RE. PLANNING APPLICATION

R/267/17/PL

Comments on Planning Application

R/267/17/PL - Rustington Hall

PROPOSED GF & FF PLANS

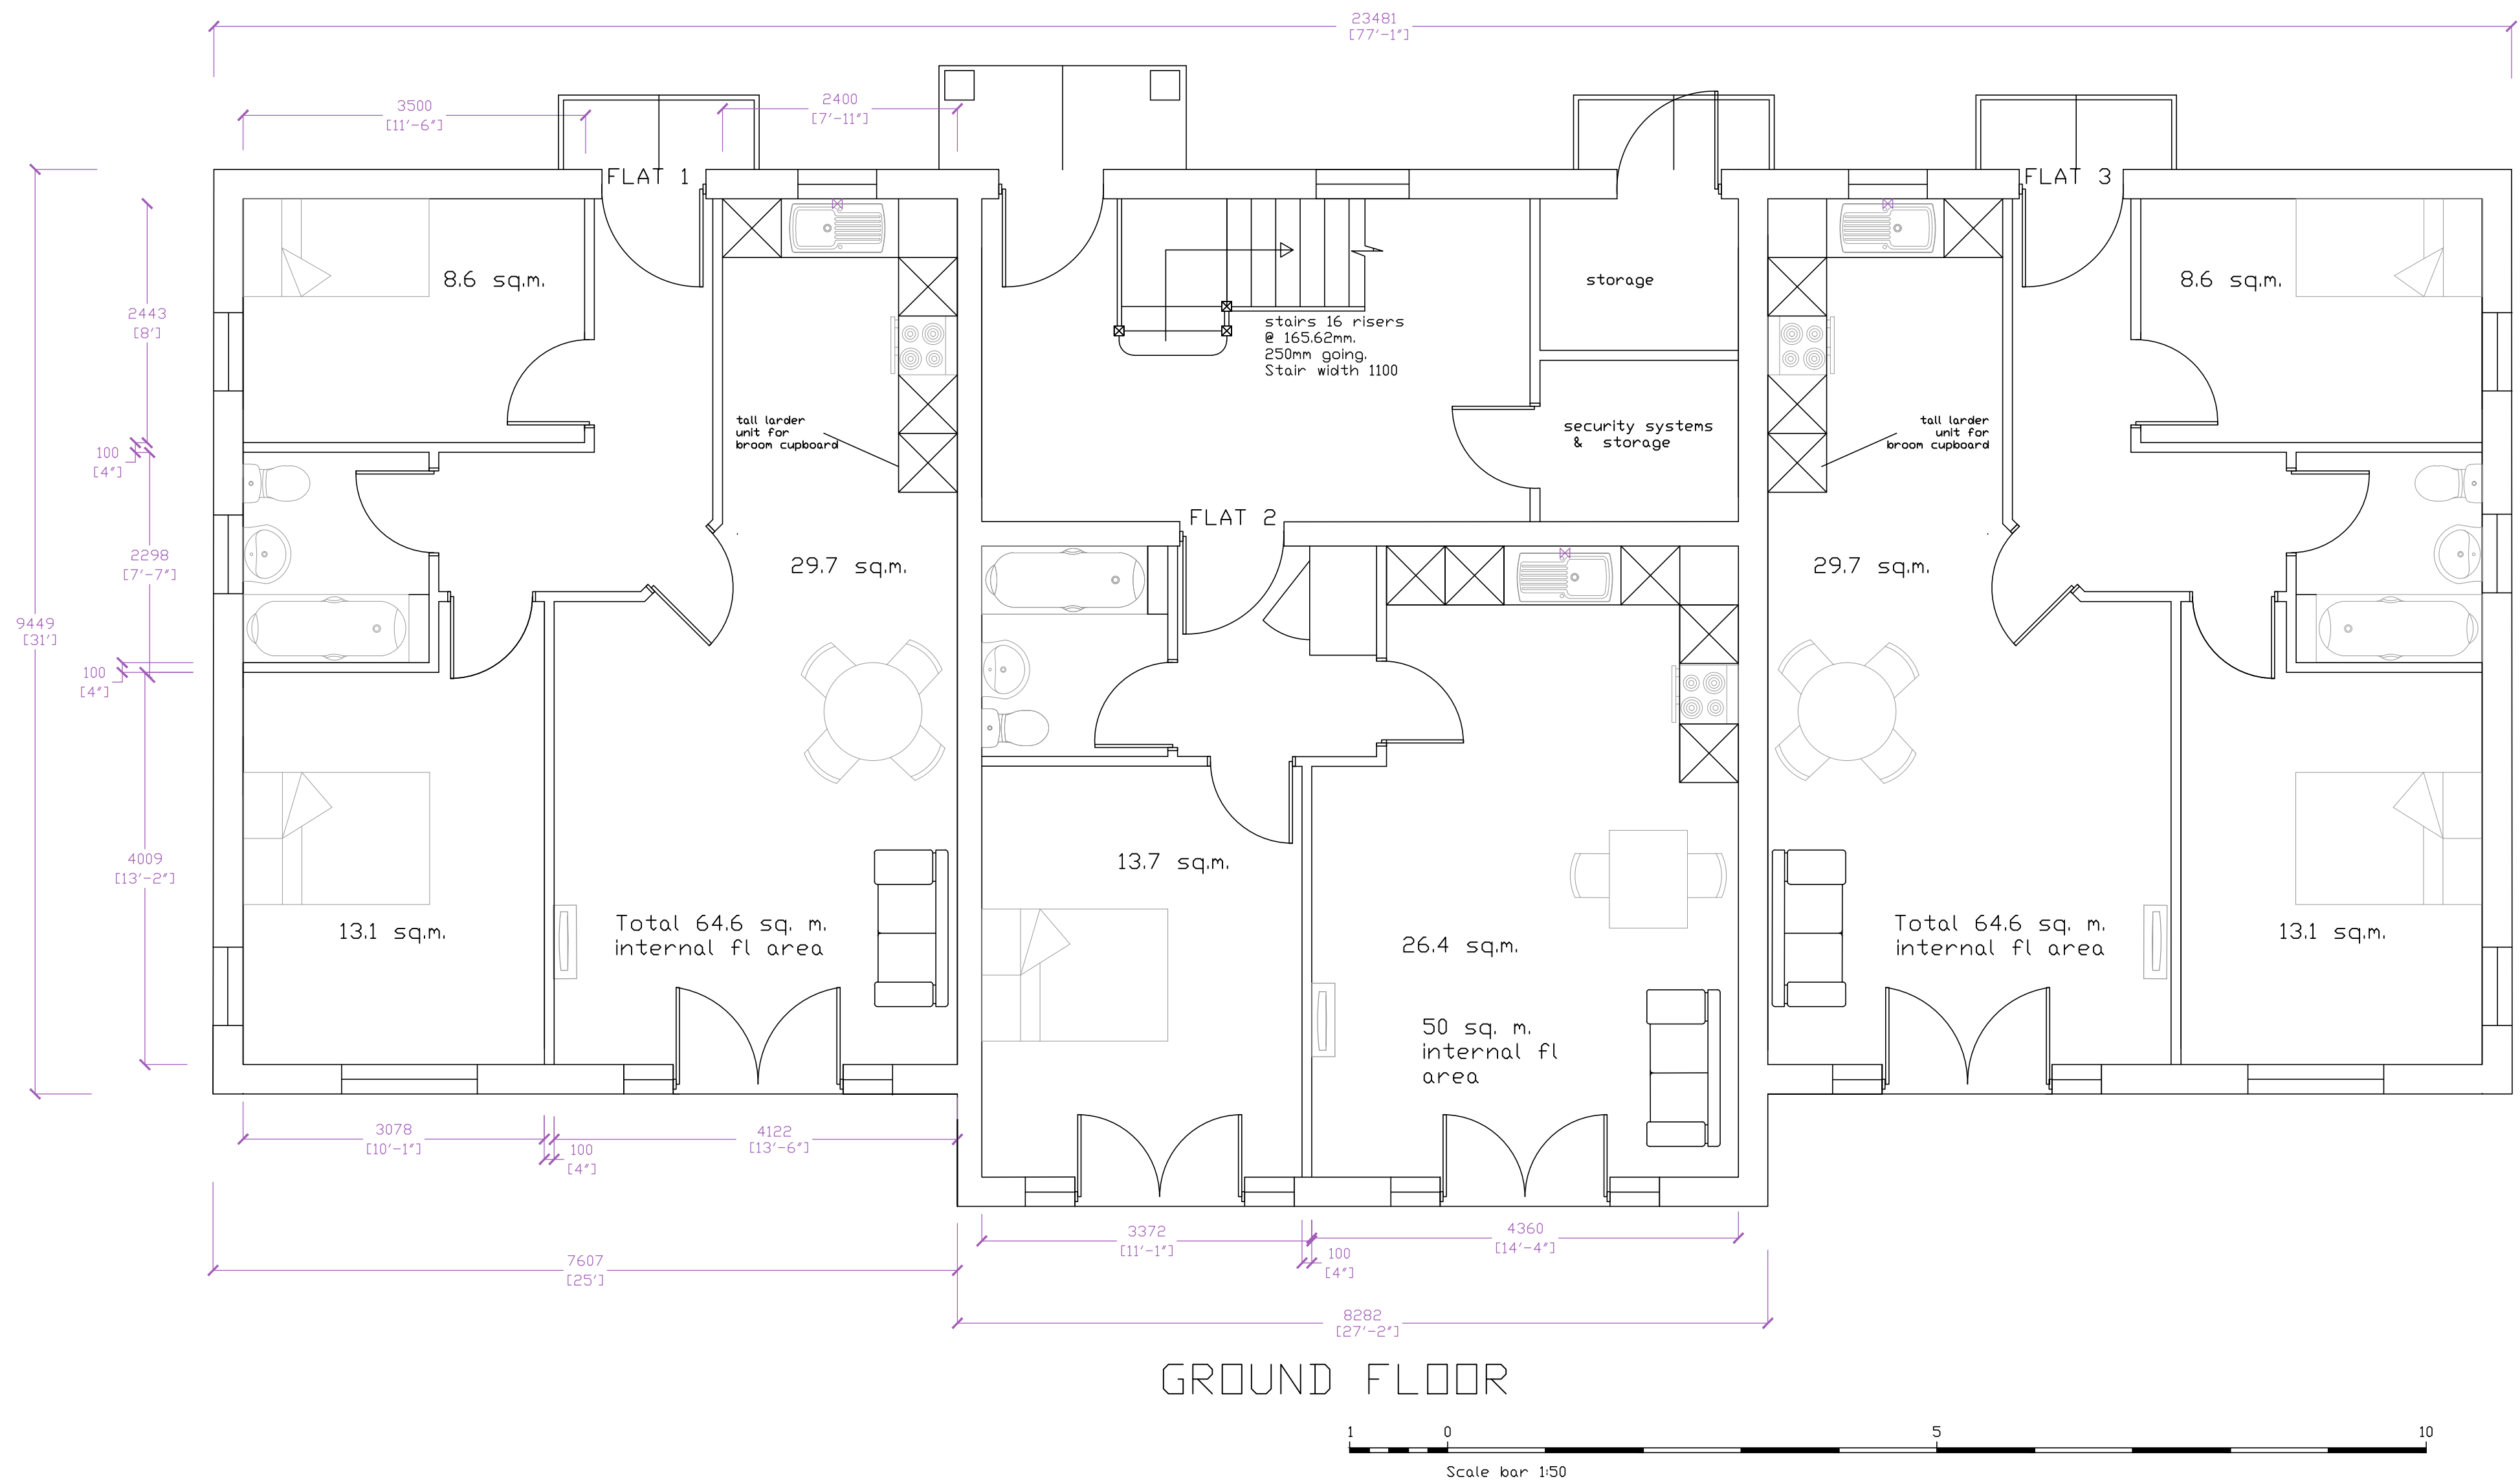
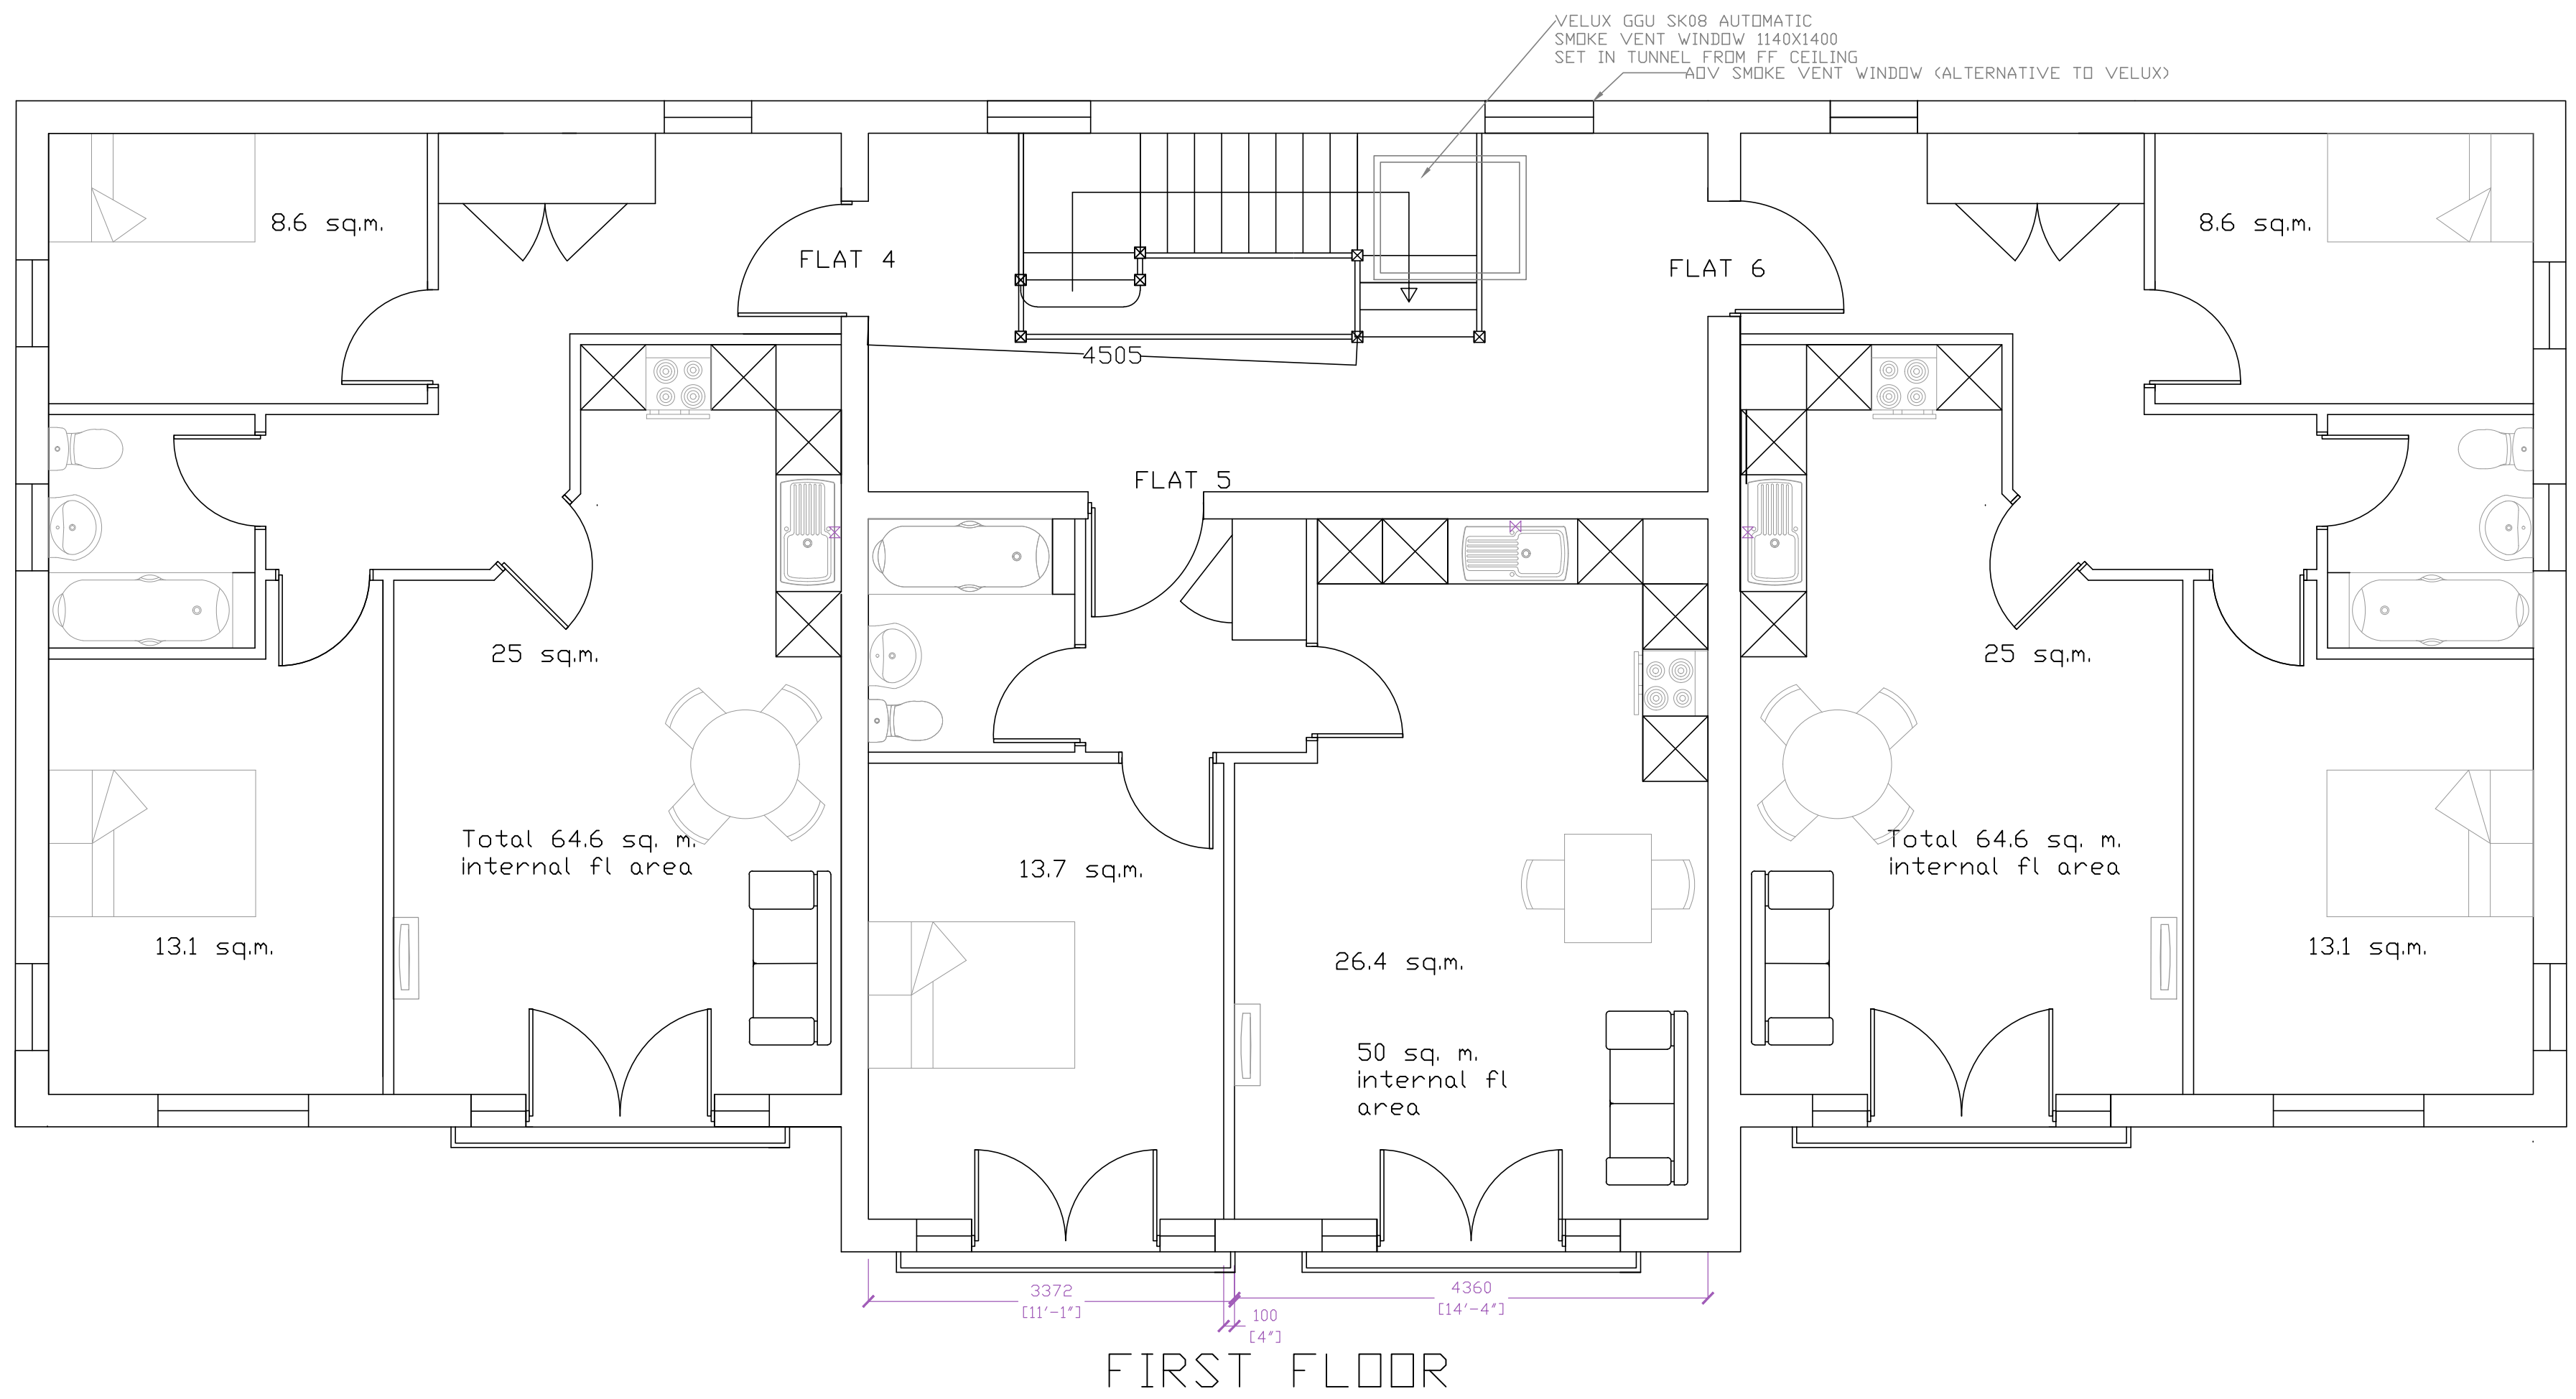
Windows to one home facing Paddock Green (shown on the plans given out at the original consultation meeting) are clear glass.

The design and height of the roof allowing for a huge third floor area with access from central stairs and windows facing all four directions appears to allow for future development.

SITE SECTIONS

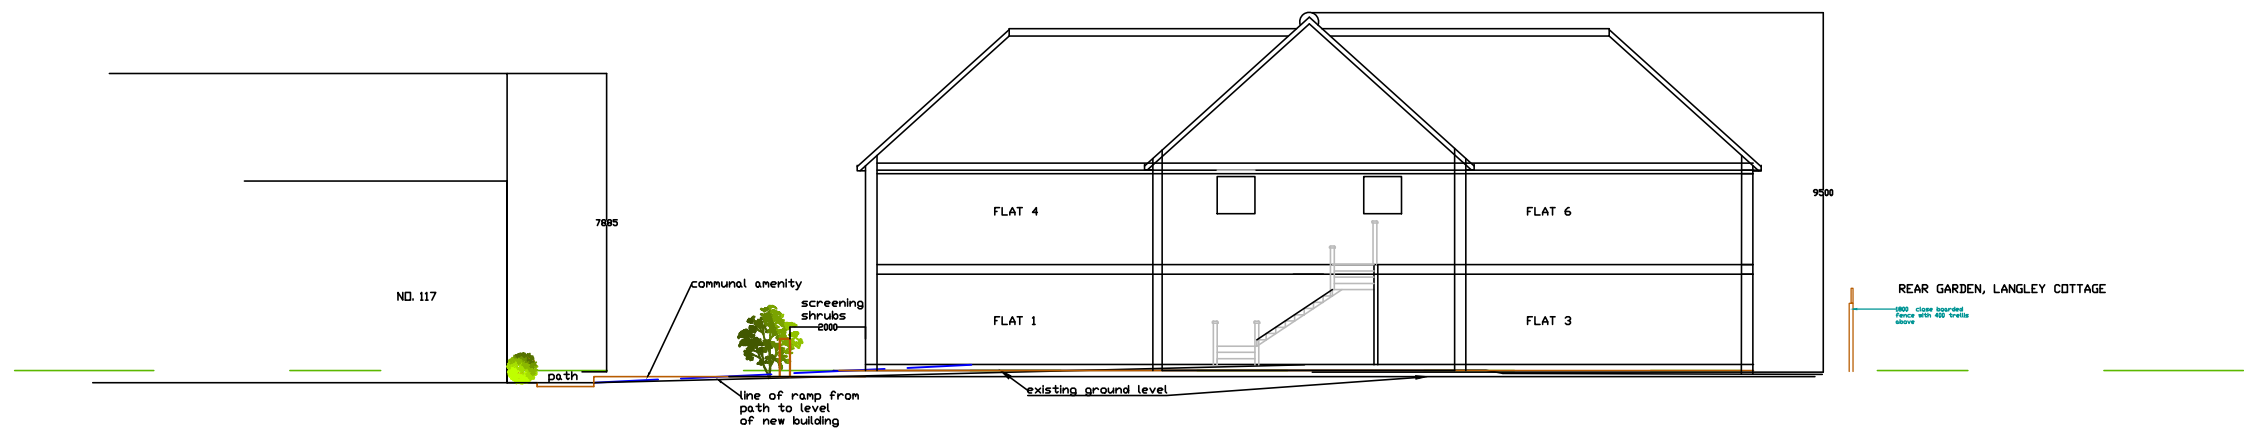
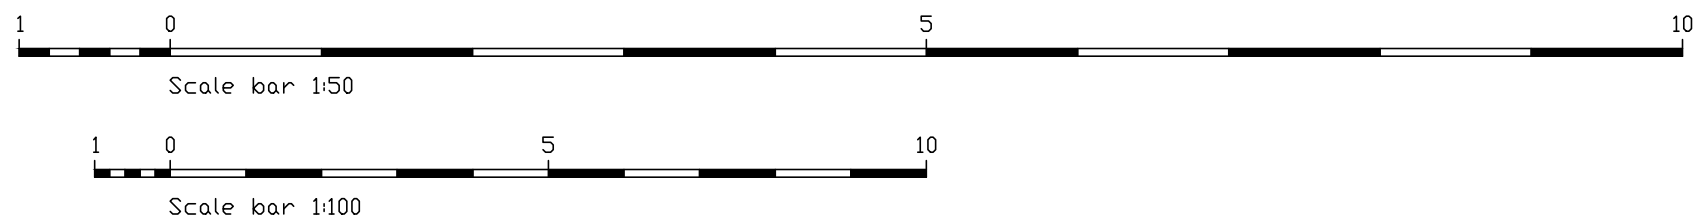
The design and height of the roof would give an over-bearing and hemmed-in effect both from the windows of Paddock Green homes and in the gardens.
